EPC STORMWATER REVIEW COMMENTS  
 IN ORANGE BOXES WITH BLACK TEXT

## EL PASO COUNTY STORMWATER MANAGEMENT PLAN CHECKLIST

EPC Project Number: **SF2318 & PPR2320**

OUTLOOK POWERS & GRINNELL GESC - INTERIM

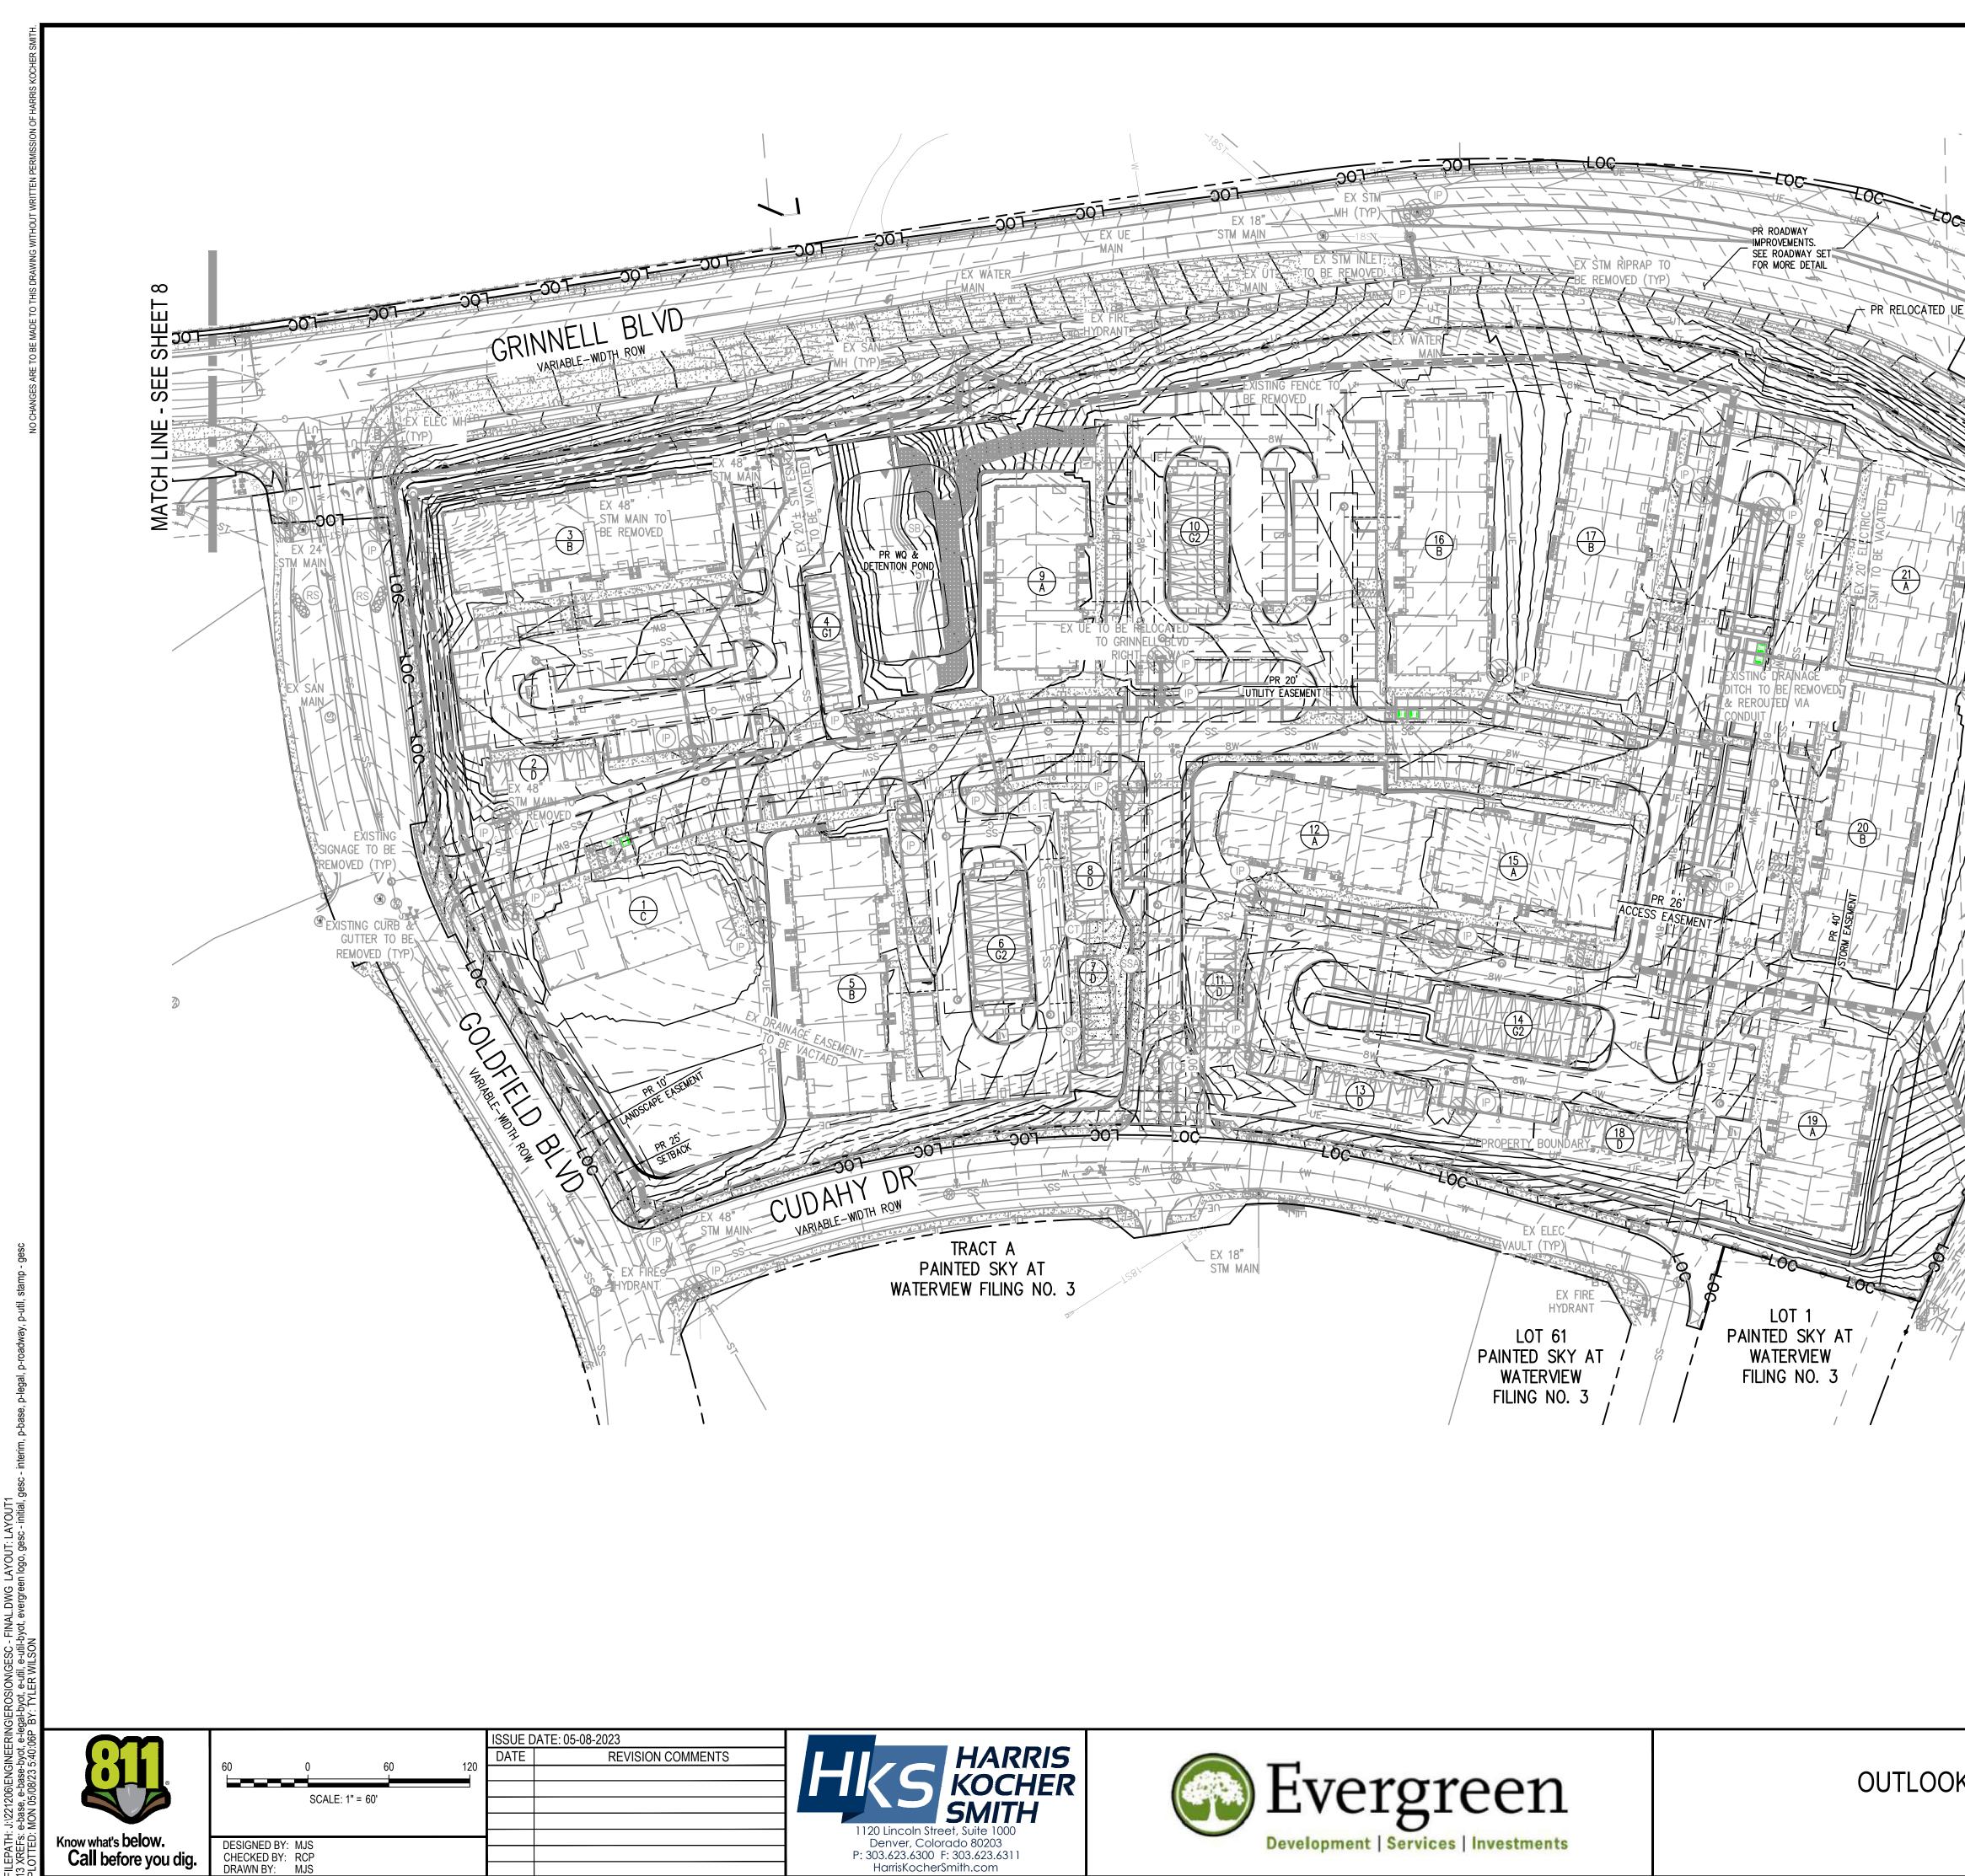
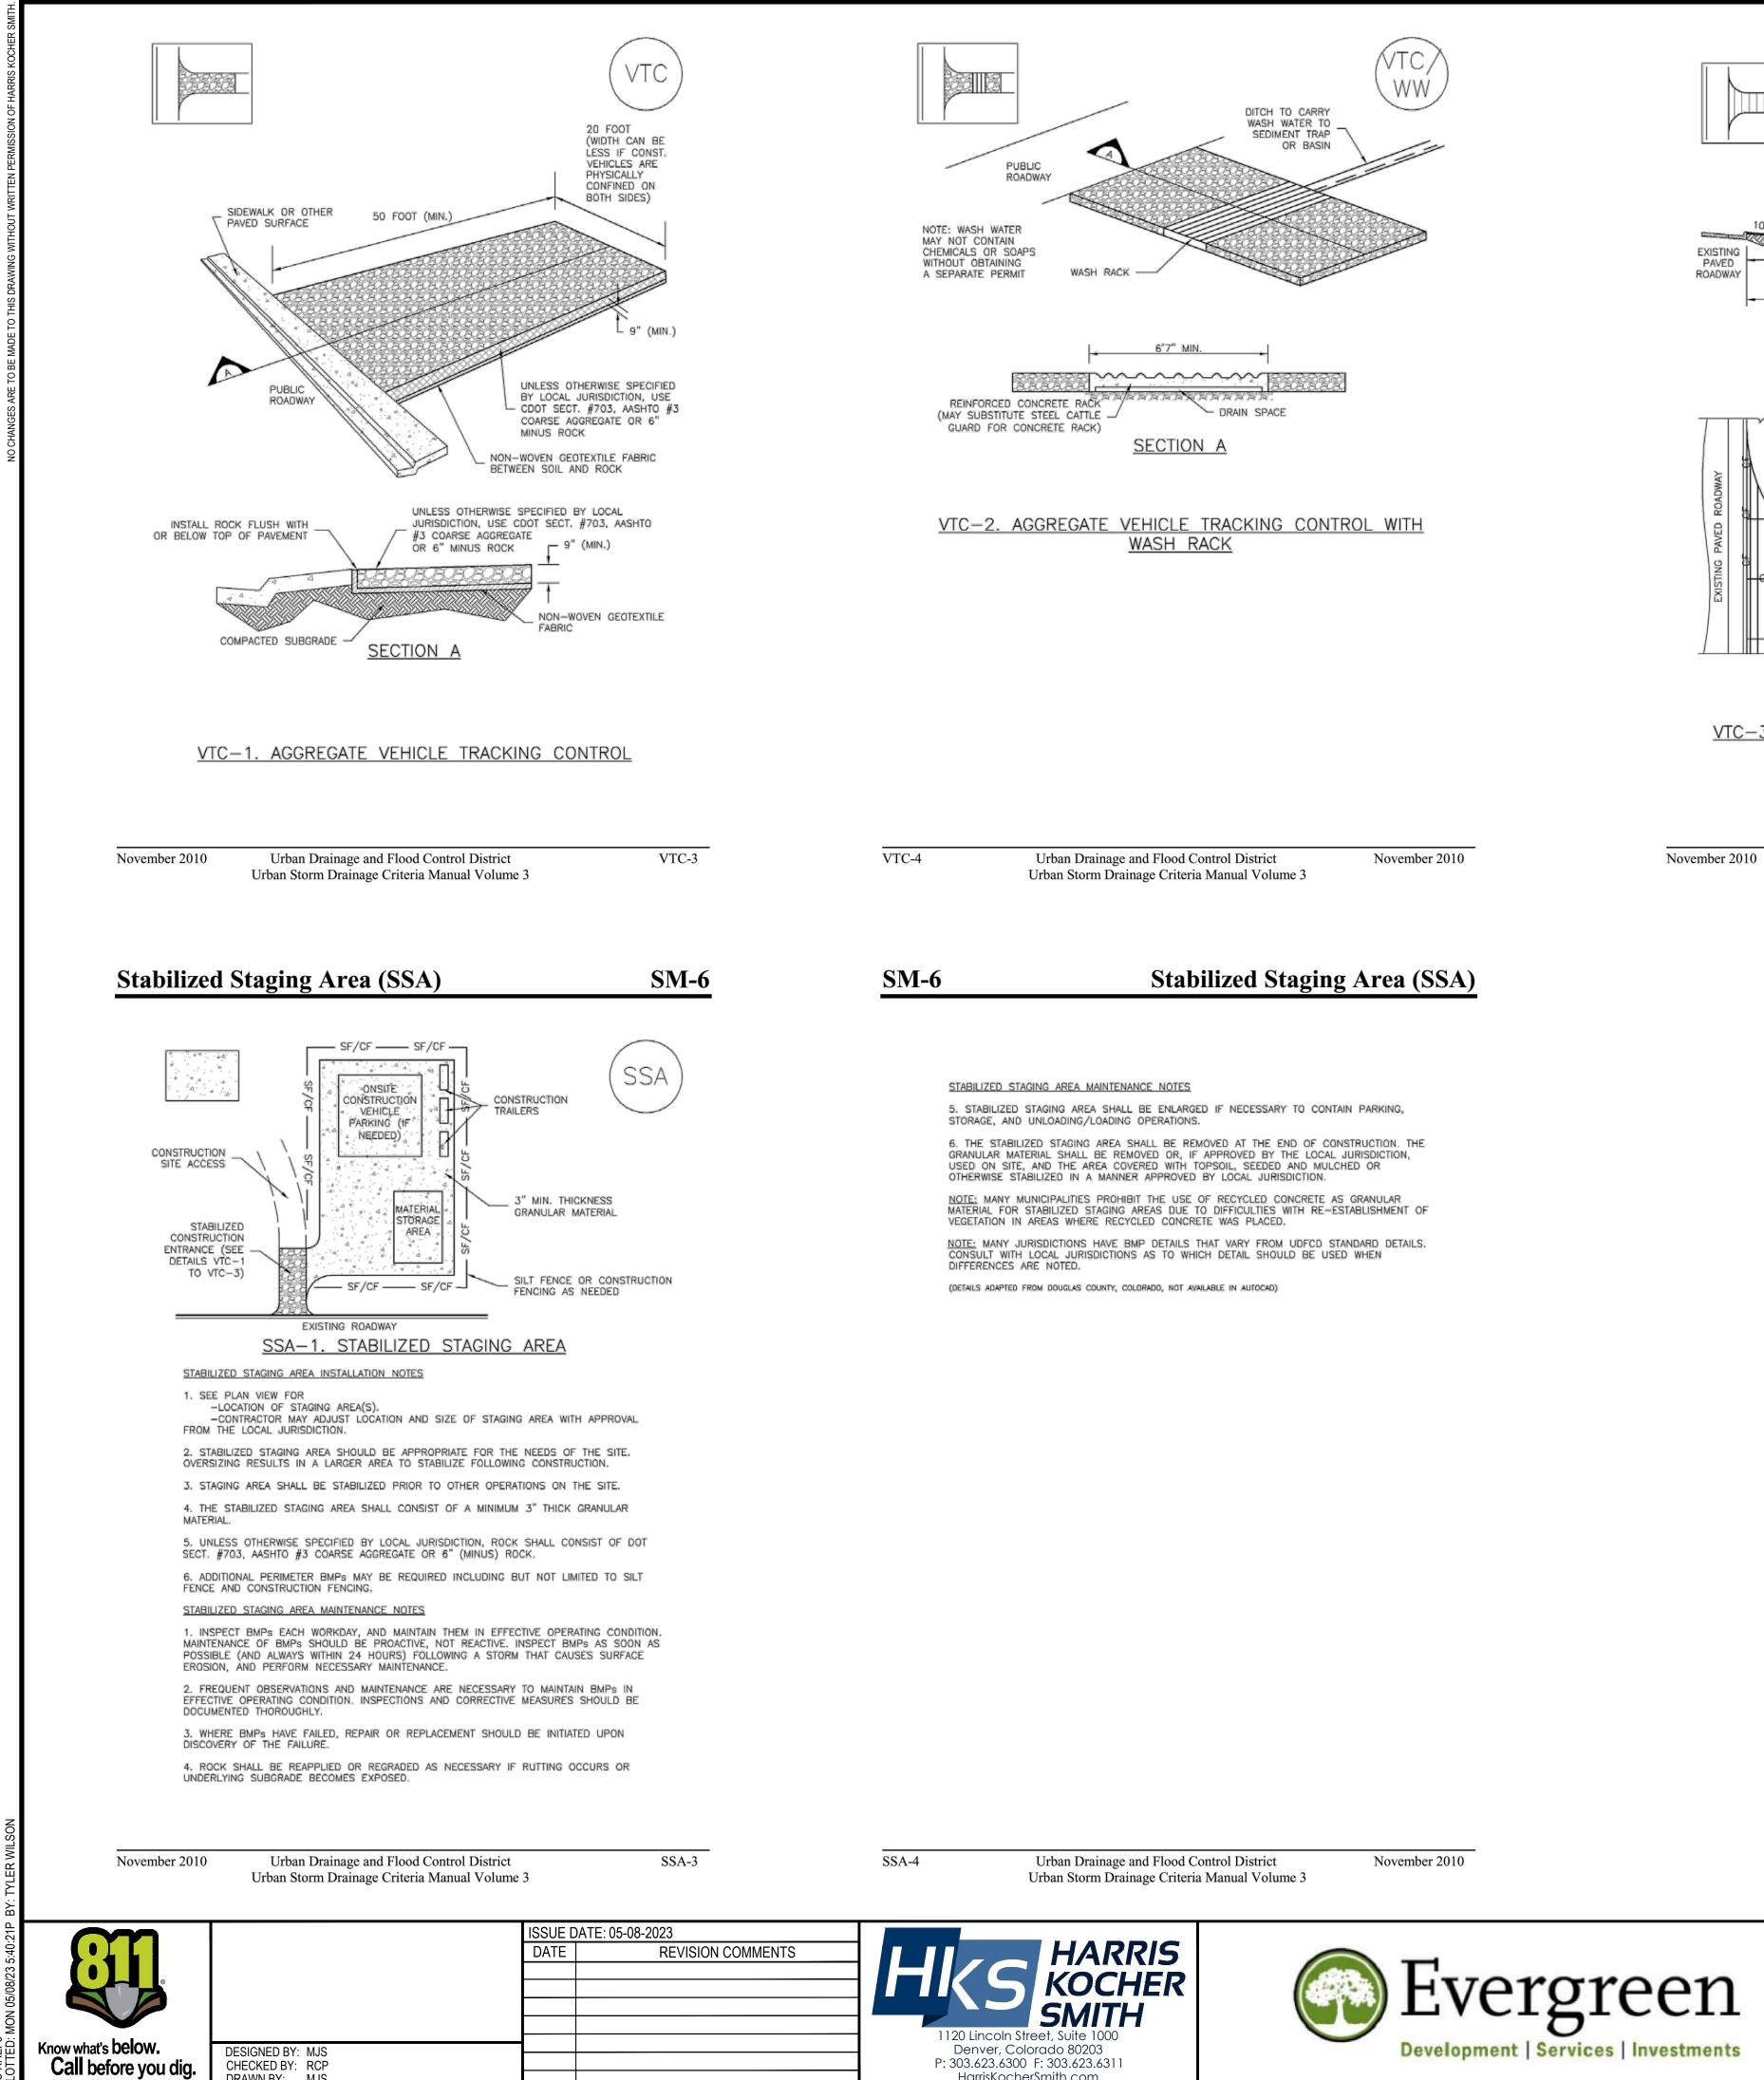
Applicant	EPC
17	SWMP Map to include: <b>Reviewed the GEC Plan</b>		
17a	construction site boundaries		Y
17b	flow arrows to depict stormwater flow directions		Y
17c	<b>all areas of disturbance</b>		N
17d	<b>areas of cut and fill</b>		N
17e	areas used for storage of building materials, soils (stockpiles) or wastes		Y
17f	<b>location of any dedicated asphalt / concrete batch plants</b>		N
17g	location of all structural control measures		Y
17h	<b>location of all non-structural control measures</b>		N
17i	springs, streams, wetlands and other surface waters, including areas that require maintenance of pre-existing vegetation within 50 feet of a receiving water		Y
18	Narrative description of all structural control measures to be used. Modifications to EPC standard control measures must meet or exceed County-approved details		Y
19	Description of all non-structural control measures to be used including seeding, mulching, protection of existing vegetation, site watering, sod placement, etc.		Y
